TfNSW Reference: SYD25/00115/02
DPHI Reference: SSD-65924461

**ENVIRONMENTAL IMPACT STATEMENT EXHIBITION - WAREHOUSE AND DISTRIBUTION CENTRE
49-61 STEPHEN ROAD, BANKSMEADOW**

TAB A

Site: 101 [101 Foreshore Rd x Botany Rd x Penrhyn Rd EX AM (Site Folder: Existing)]

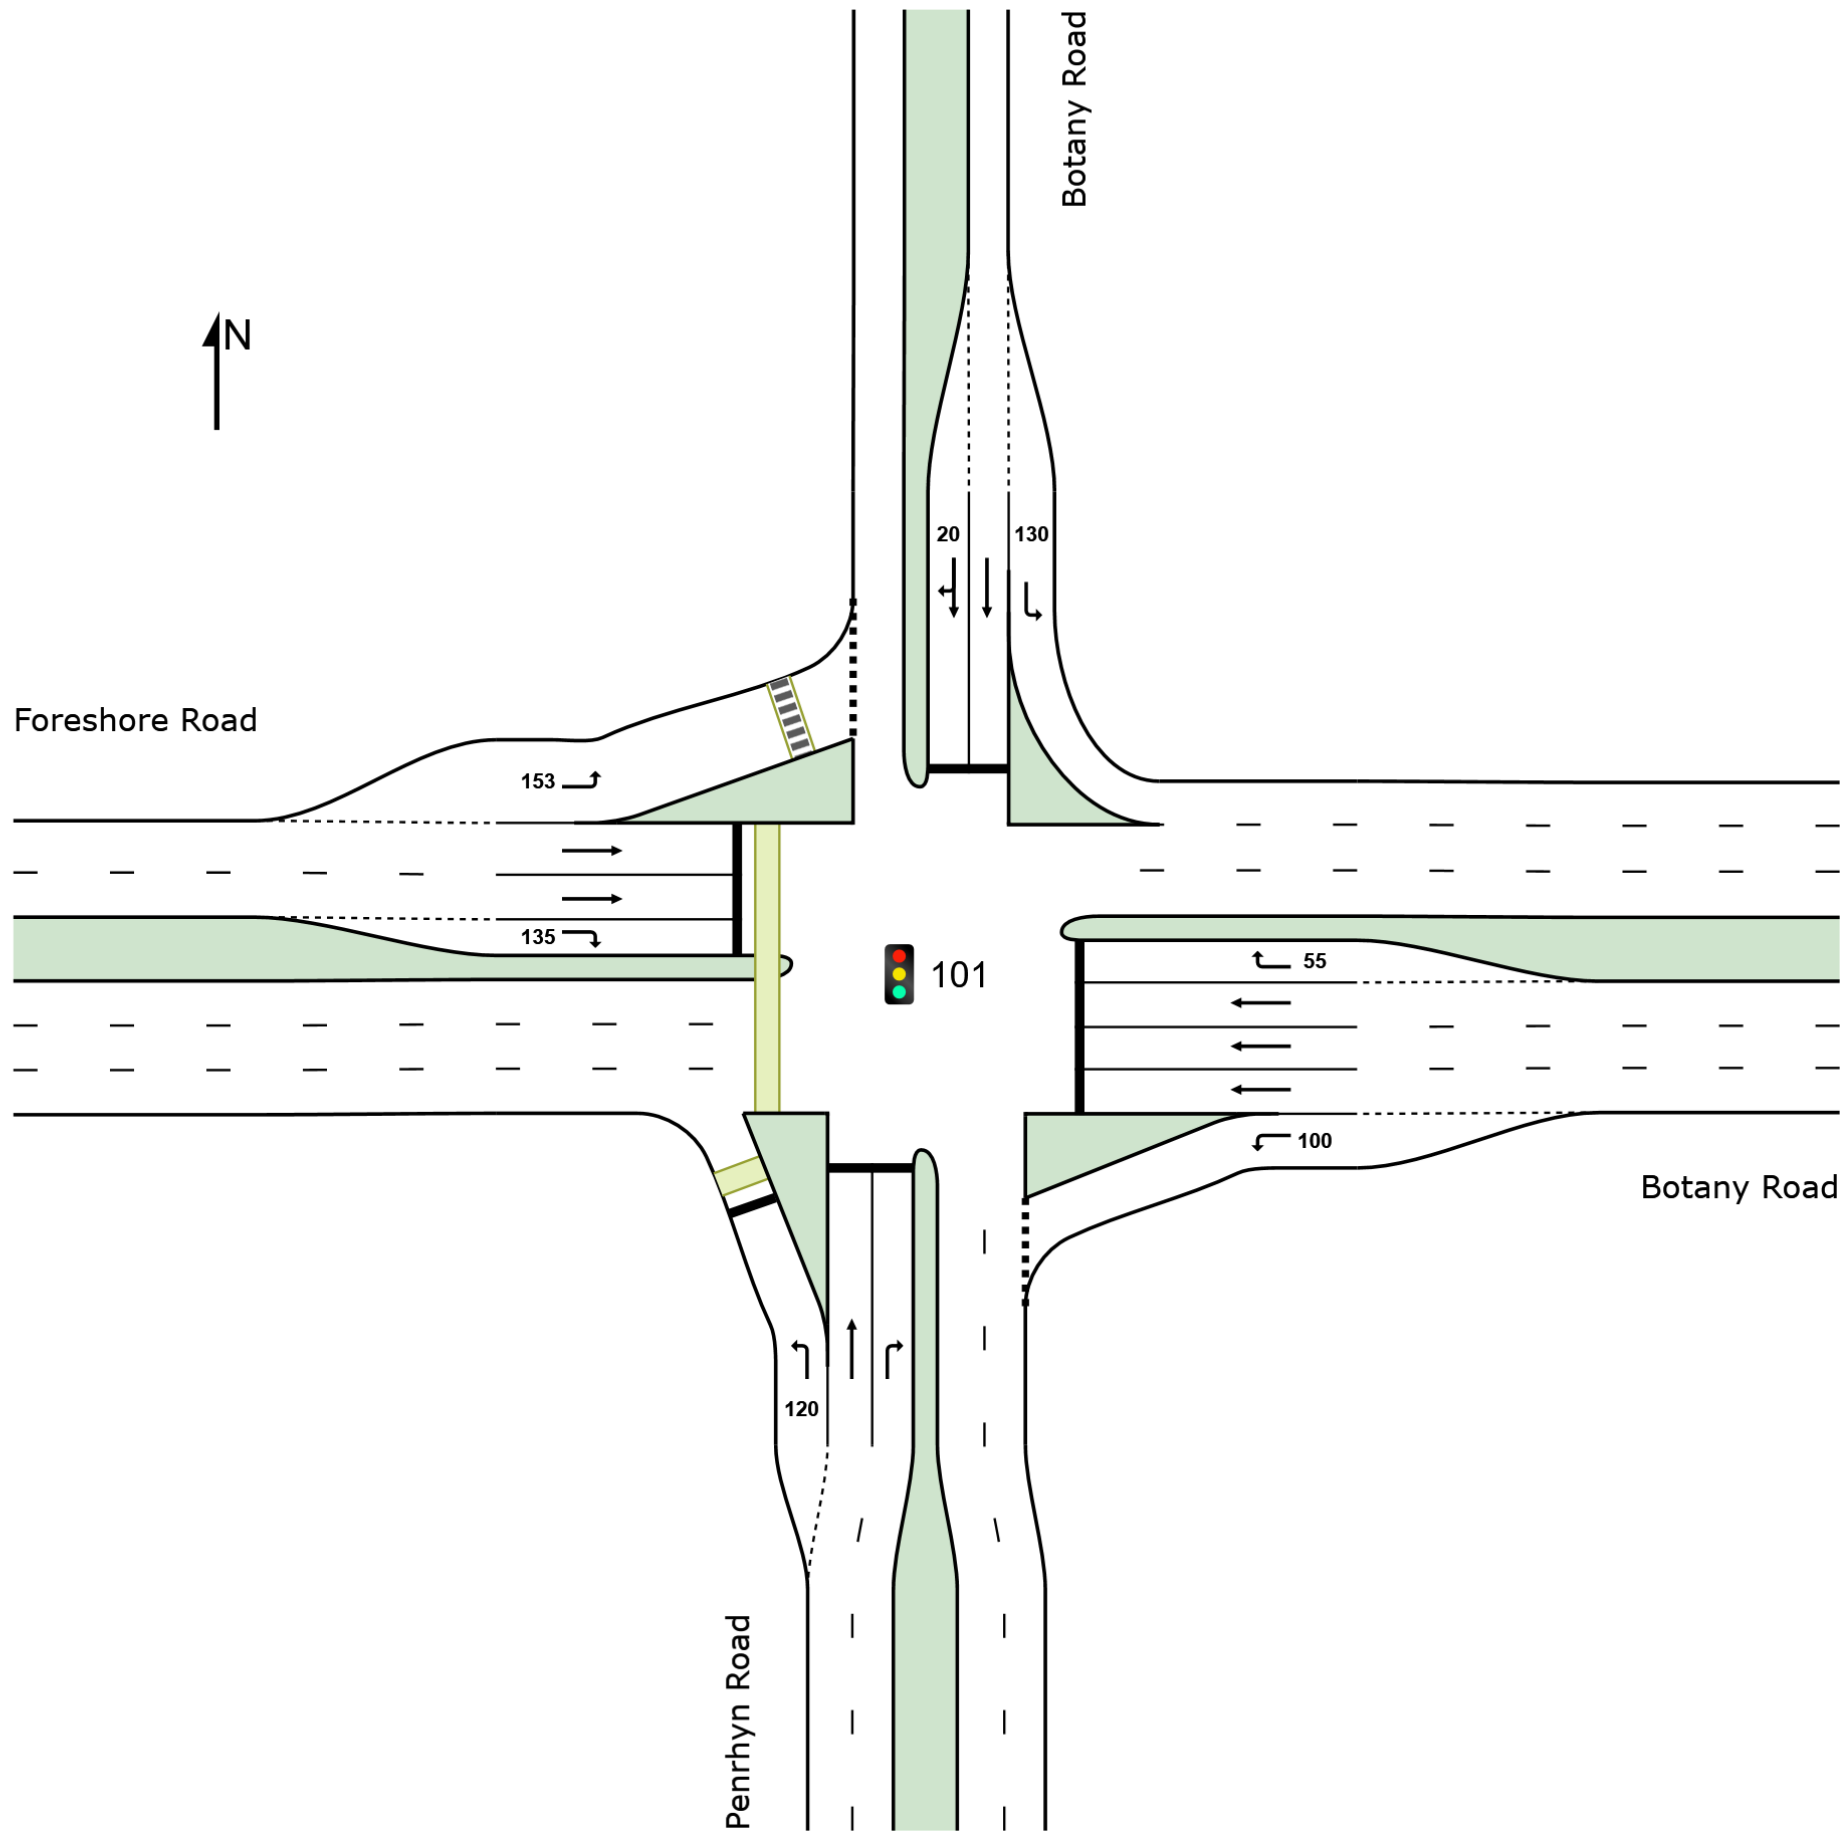
- iv) The cycle times modelled for the two signalised intersections appear incorrect. Please confirm the cycle times on the day of the survey as a review of SCATS plan data indicates the following cycle times:

▽ Site: 301 [301 Botany Rd x Hills St EX AM (Site Folder: Existing)]

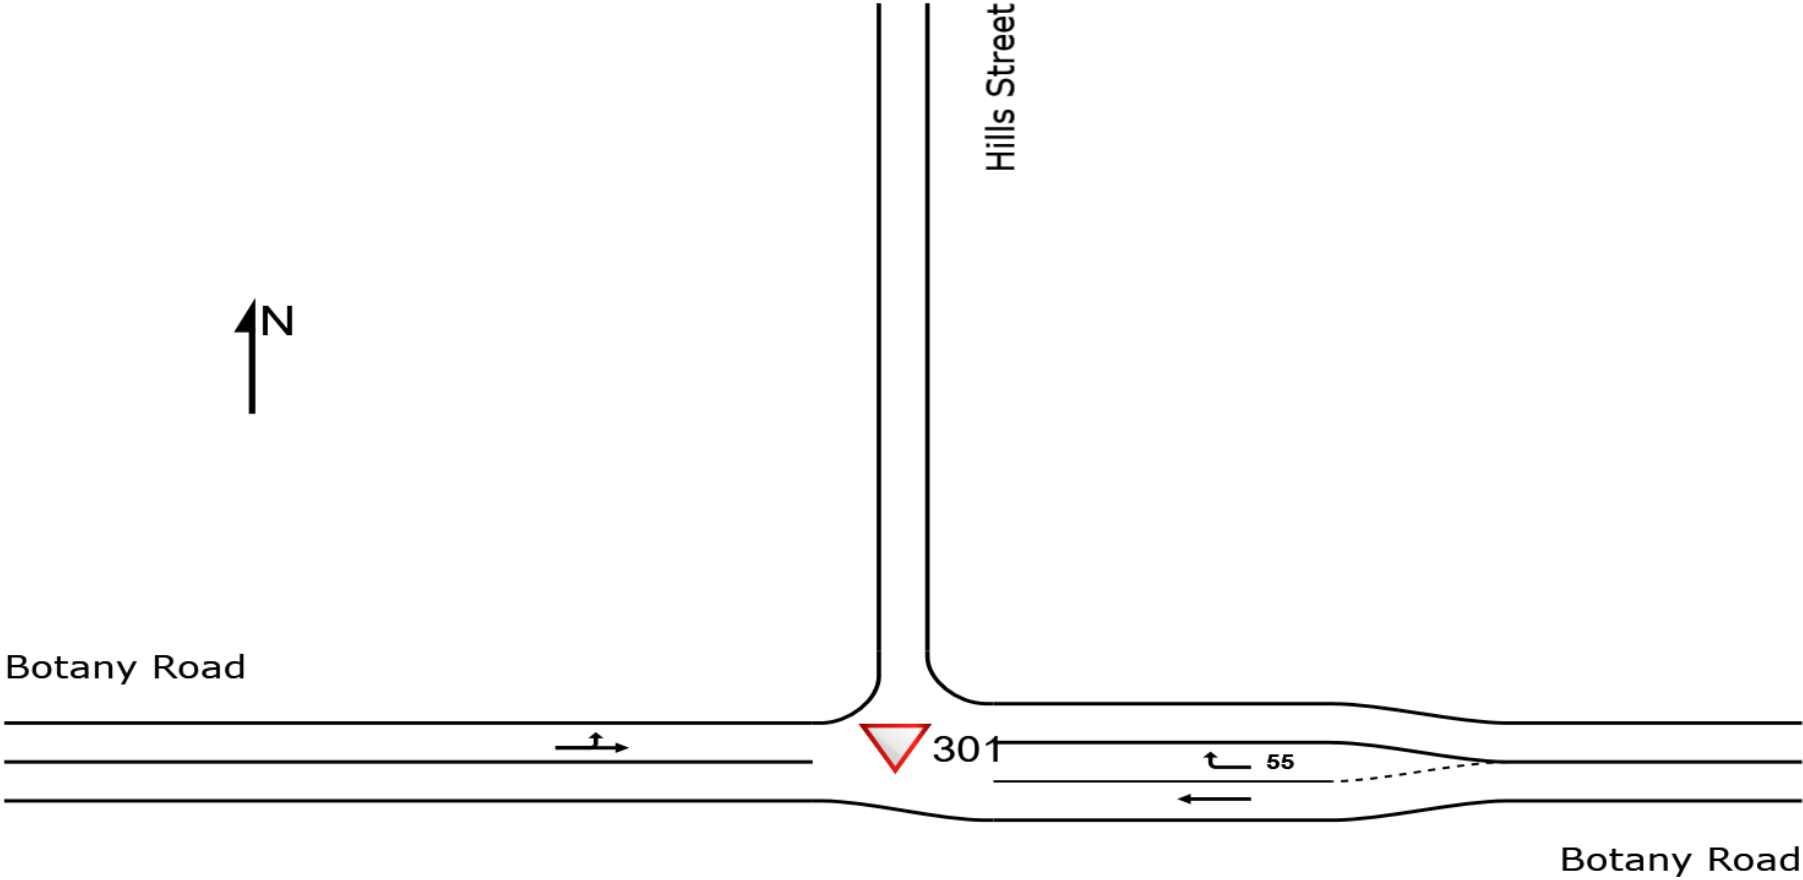
In other instances, the right turn bay distances seem to be out of date. For example, for the intersection of Botany Road and Hills Street the TIA has coded the Botany Road right turn bay as being 55m in length, whereas TfNSW information indicates that this is in fact over 220m in length (see image below).
